**CITY OF ALBUQUERQUE
PLANNING DEPARTMENT
June 9, 2010
DRB Comments**

PROJECT # 1008364

APPLICATION # 10-70154

RE: Lots 8 & 9, Stonegate Village

# SKETCH PLAT LOT LINE ADJUSTMENT LOTS 8A & 9A STONEGATE VILLAGE

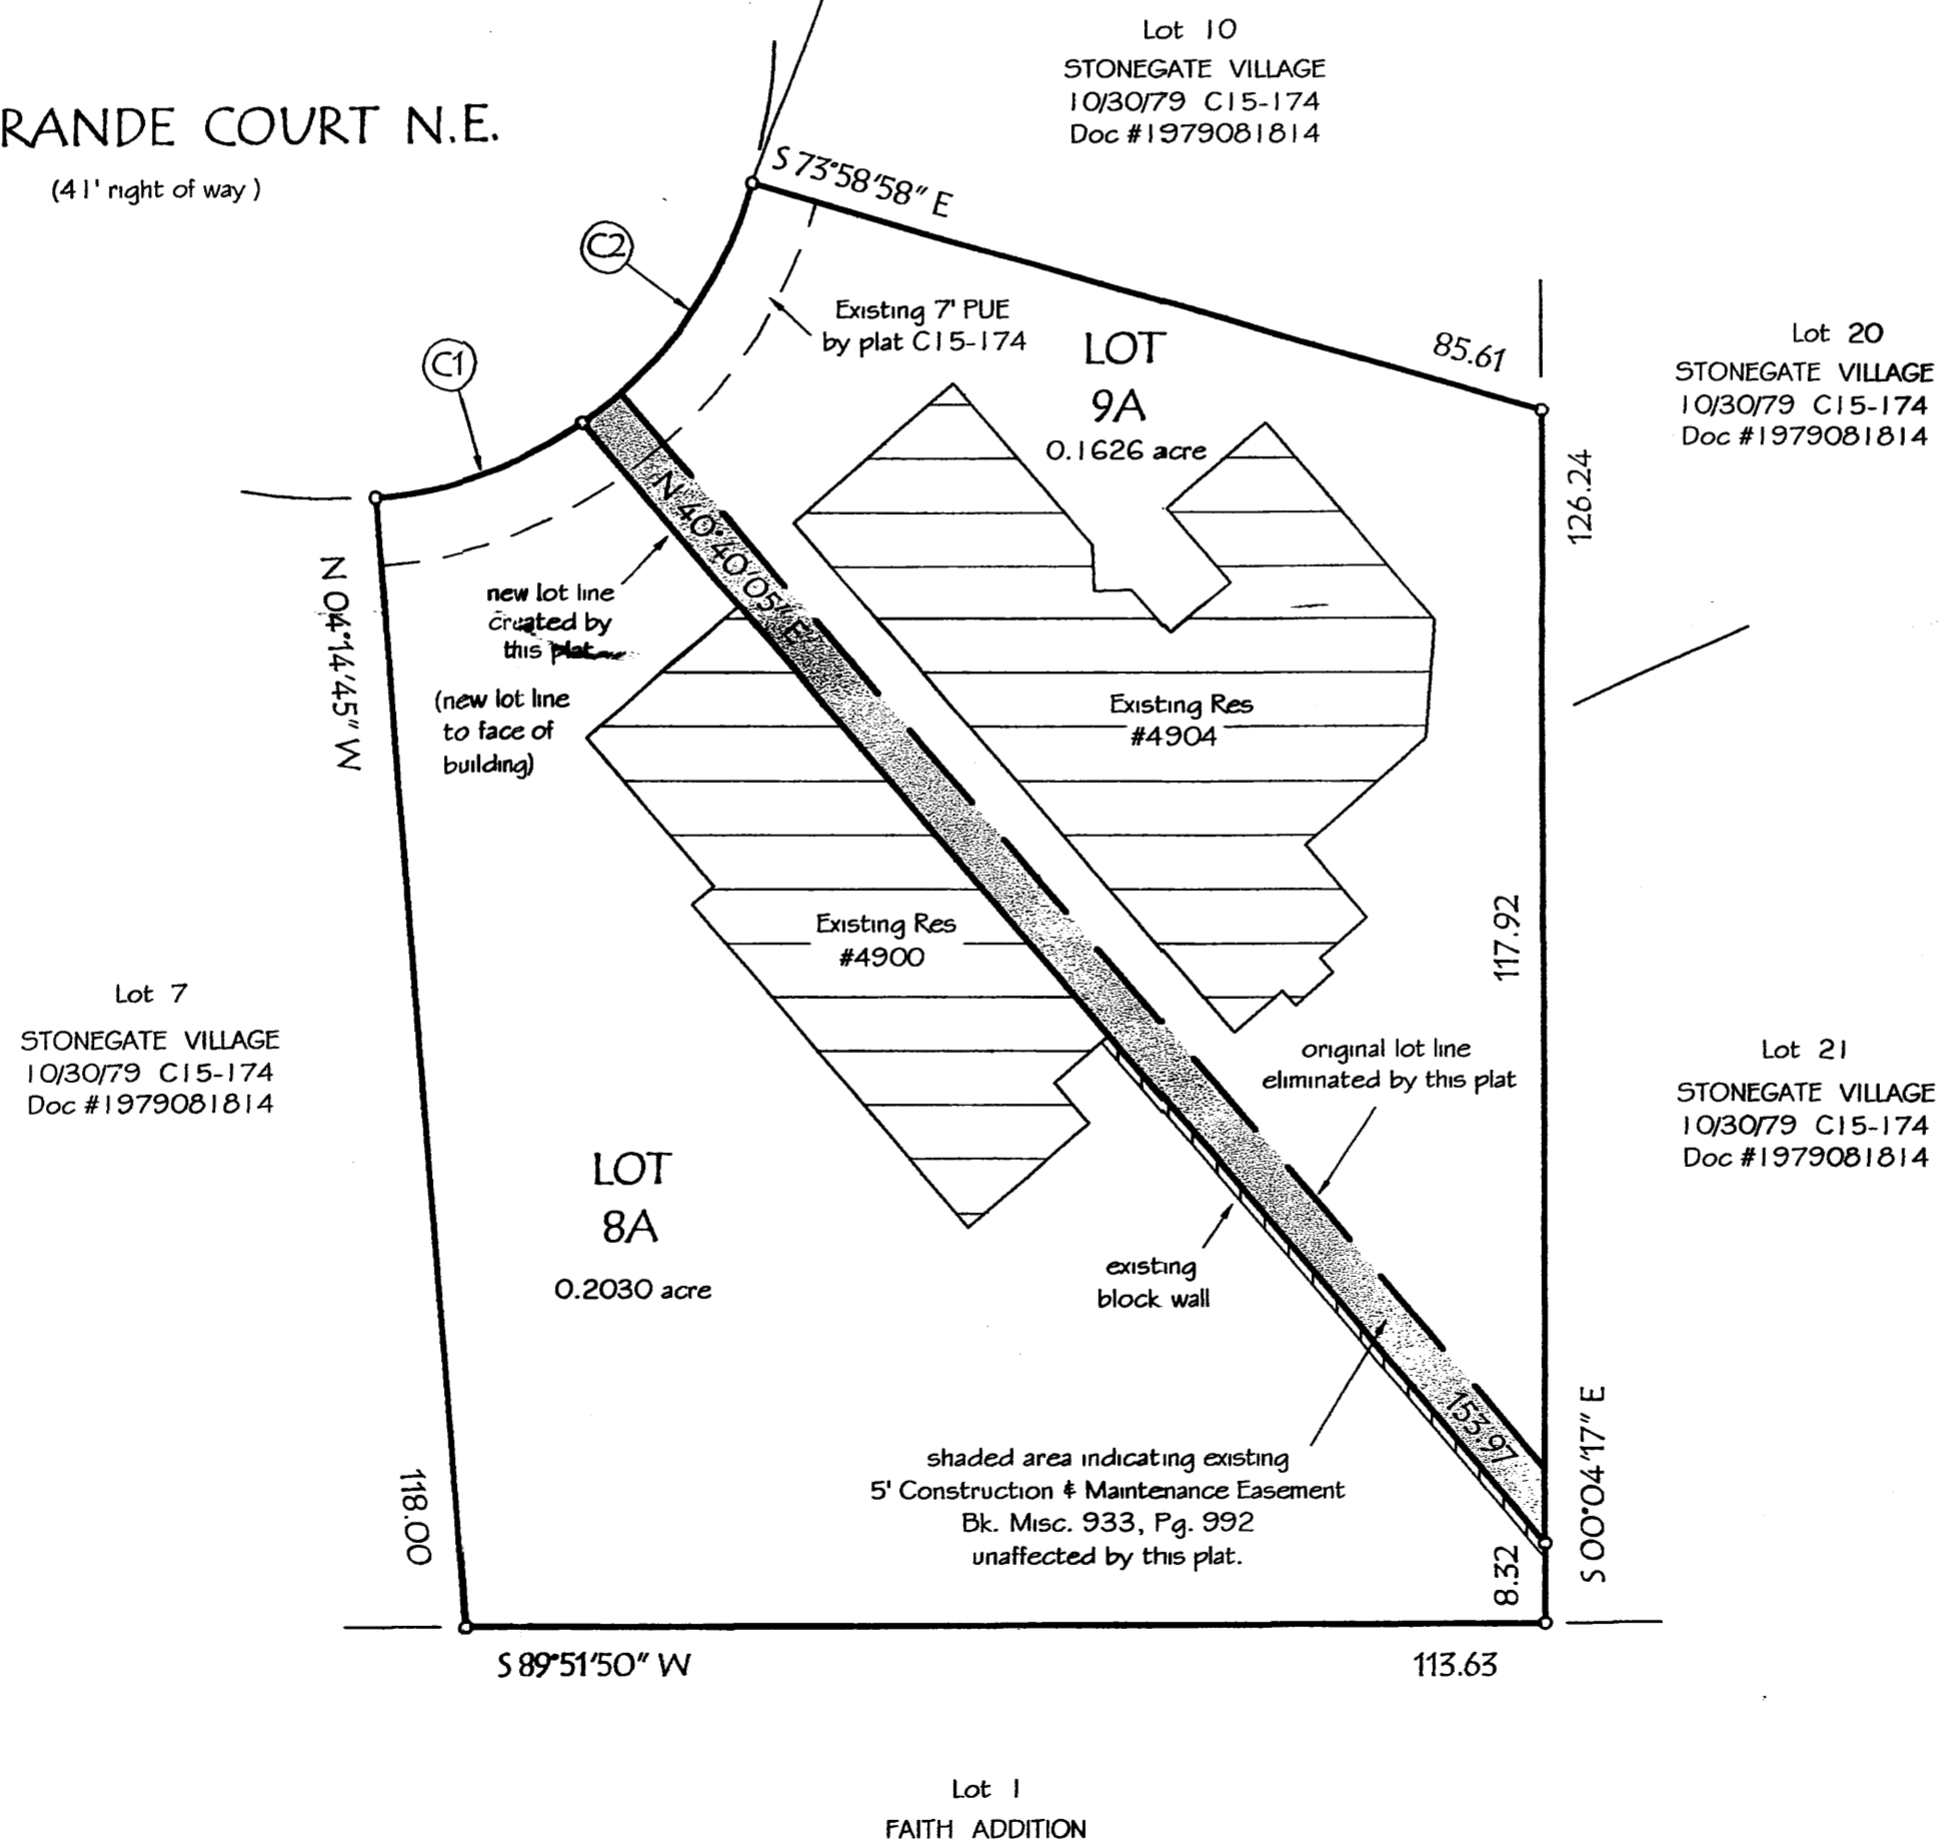
Certification is needed that the existing structure on Lot 8 will comply with the building code regarding the proposed lot line.

A Solar Note consistent with § 14-14-4-7 of the Subdivision Ordinance will be required.

This is to certify that the existing structure (single-family dwelling) on Lot numbered Eight (8) of STONEGATE VILLAGE, having a physical address of 4900 Oso Grande Court N.E., Albuquerque, New Mexico, 87111, complies with the City of Albuquerque Building Code regarding the proposed lot line in this case. The wall of the existing structure adjacent to the proposed lot line meets the requirements for a "One (1) hour fire resistant wall" as described in Section R317 of the International Residential Code.
